DELEGATED HOUSEHOLDER DECISION

Item No.	Report of the Head of Development Management and Building Control	
Address:	247 WEST END ROAD RUISLIP	
Development:	Conversion of roof space to habitable use, including the construction of one rear dormer and one side dormer and the installation of two front roof lights	
LBH Ref Nos:	28177/APP/2025/200	
Drawing Nos:	ABC391 / 8002 - Proposed Ground and First floor plans and Roof Pla ABC391 / 8003 - Proposed Street Elevations Covering letter Homes Design Ltd Block Plan Fire Strategy Letter Letter, RE Design and Access, prepared by Homes Design Ltd, dated 18.01.2025 Location Plan ABC391 / 8000 ABC391 / 8001	
Date Plans received:	28-01-25	Date(s) of Amendments(s):
Date Application valid	28-01-25

title		PROPOSED PLANS	
project		NEW DWELLING AT LAND ADJACENT TO 247 WEST END ROAD RUISLIP HA4 6QR	
drawing no		ABC391 / 8002	
drawn by		R. L	contract no. ABC391
scale		1:100 @ A3	date 01/2025

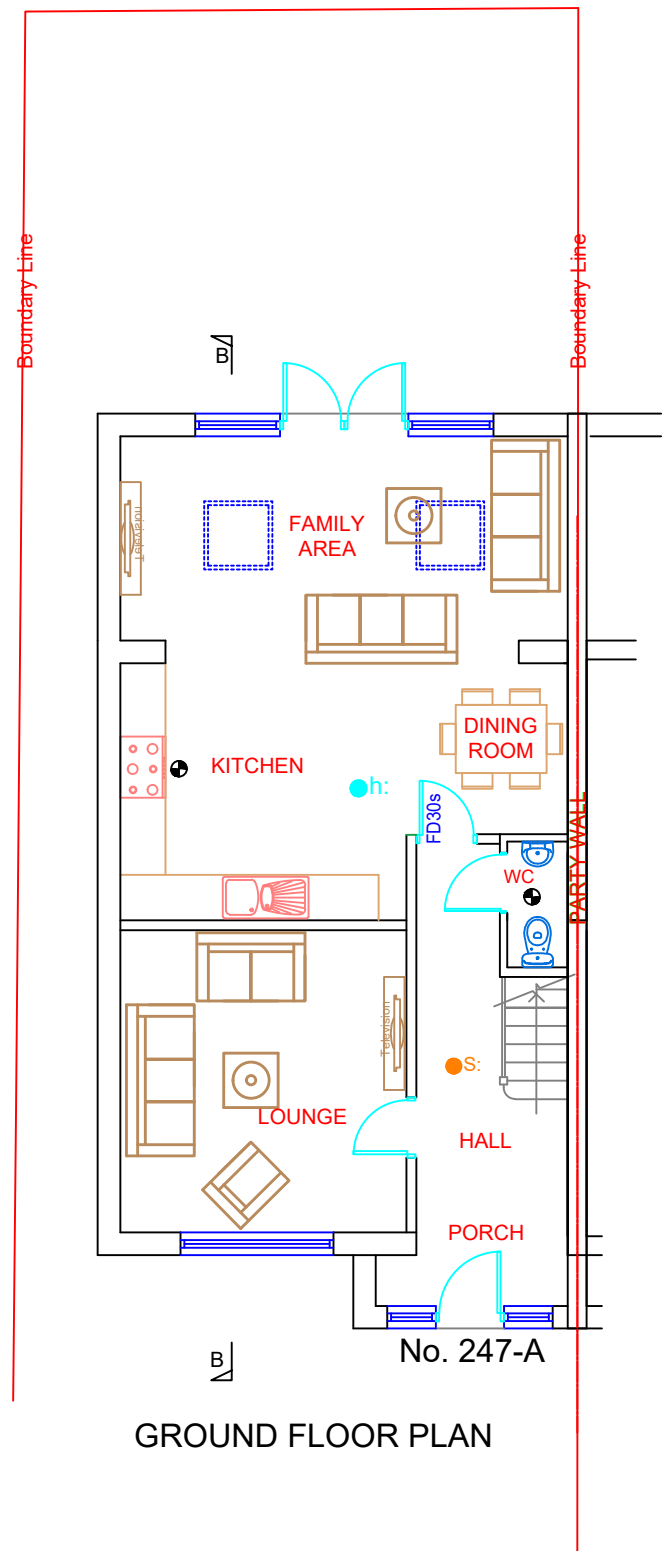
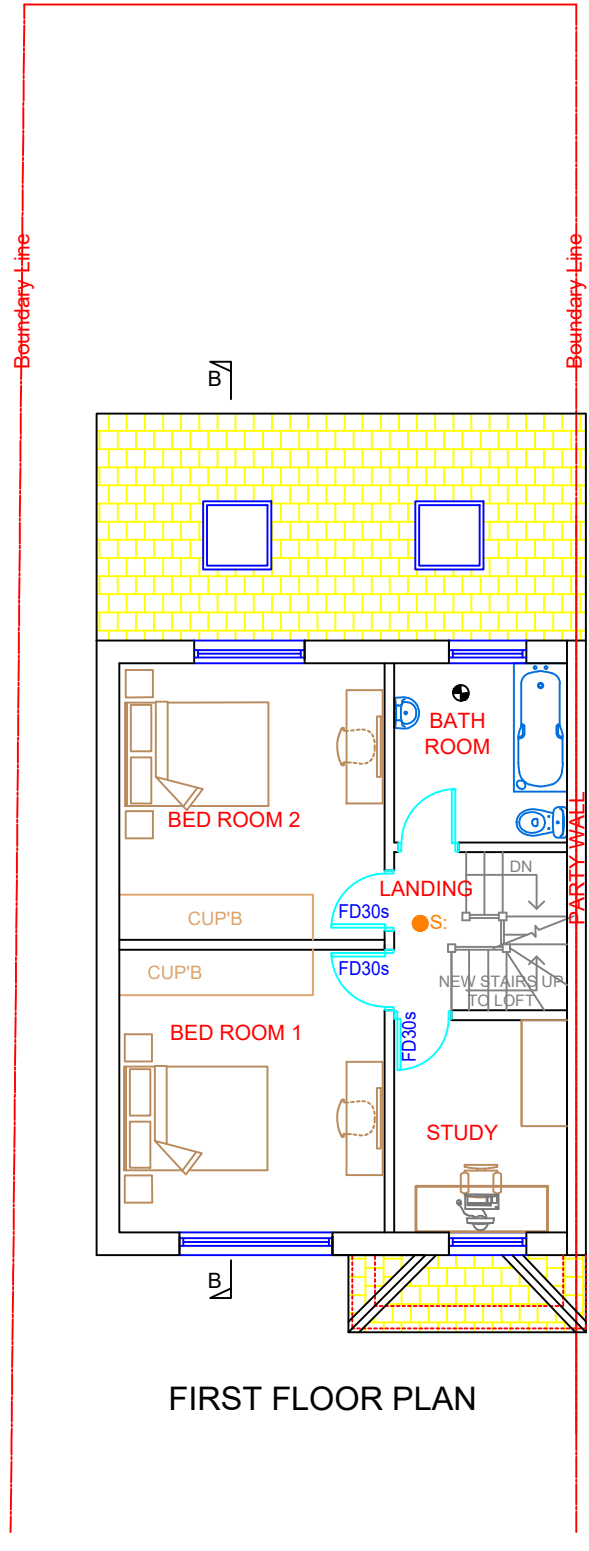
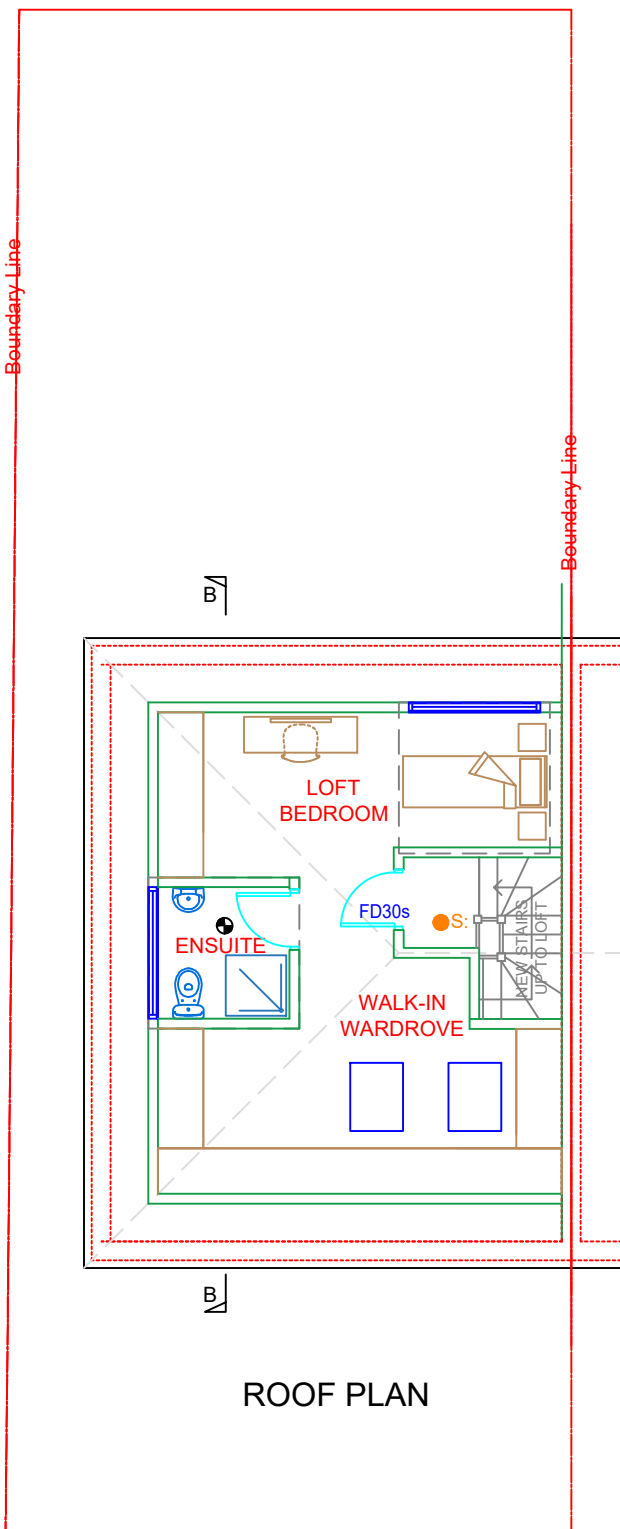
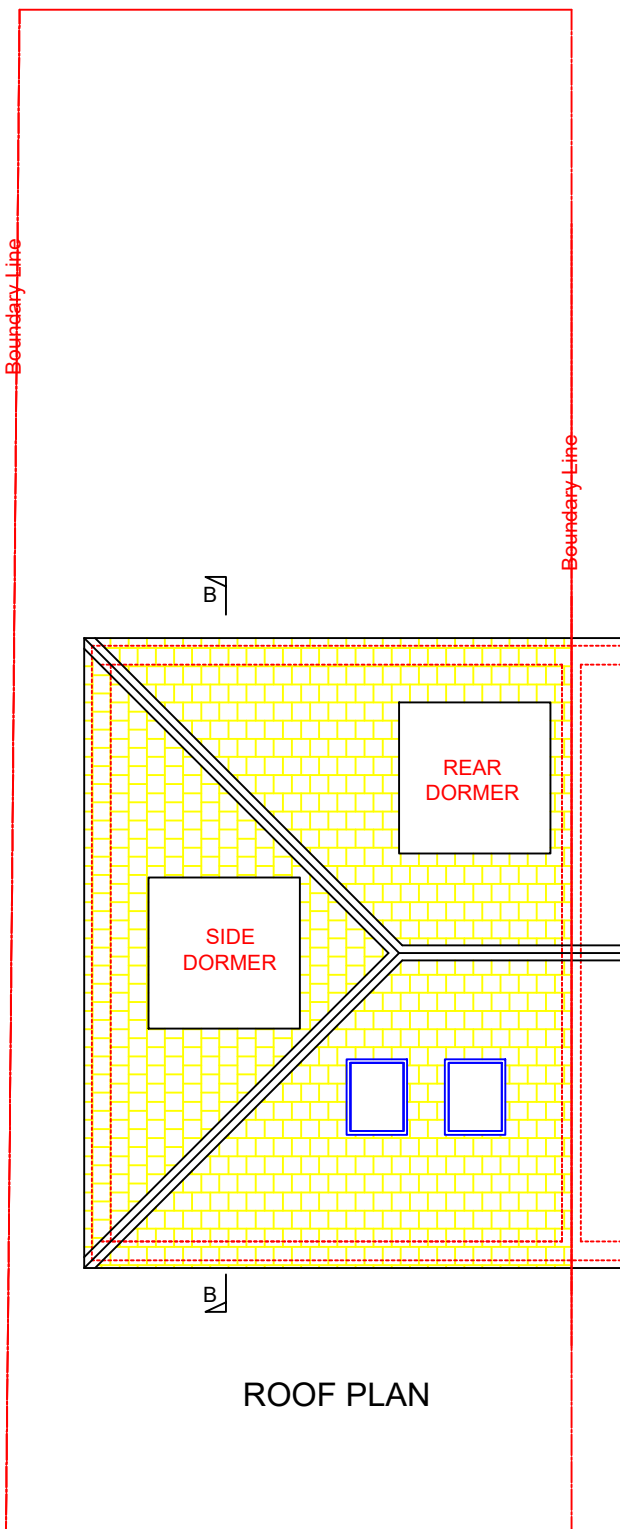
The proposed dormers would be appropriately set down from the roof's ridge line, up from the eaves, and in from the property's sides. The works would appear subordinate and subservient to the main dwelling and would not be an overly large roof extensions. Notwithstanding, the works would be contrary to Policy DMHD 1 in that they would not be at the rear of the property. One modest dormer is proposed on the side roof slope. However, significant weight is given to permitted development rights as per the Town and Country Planning (General Permitted Development) (England) Order 2015 (as amended). Given the side dormer's considered scale and design, it is acceptable with regard to character and appearance.

The two proposed front-facing rooflights would not impact residential amenity as they would face the public street and are angled upwards. The windows on the side-facing roof dormer would be obscurely glazed. This is secured by condition. As such, the obscured window would not result in inappropriate overlooking or harm to neighbouring residential amenity. The rear-facing roof dormer would be no closer to neighbouring properties than the existing rear-facing upper-floor windows of properties on this terrace. Therefore, the outlook is acceptable and would not result in undue

4. HO6 Obscure Glazing

The dormer window to be installed facing the neighbouring property (239 West End Road) shall be glazed with permanently obscured glass to at least scale 4 on the Pilkington scale and be non-opening below a height of 1.7 metres taken from internal finished floor level for so long as the development remains in existence.
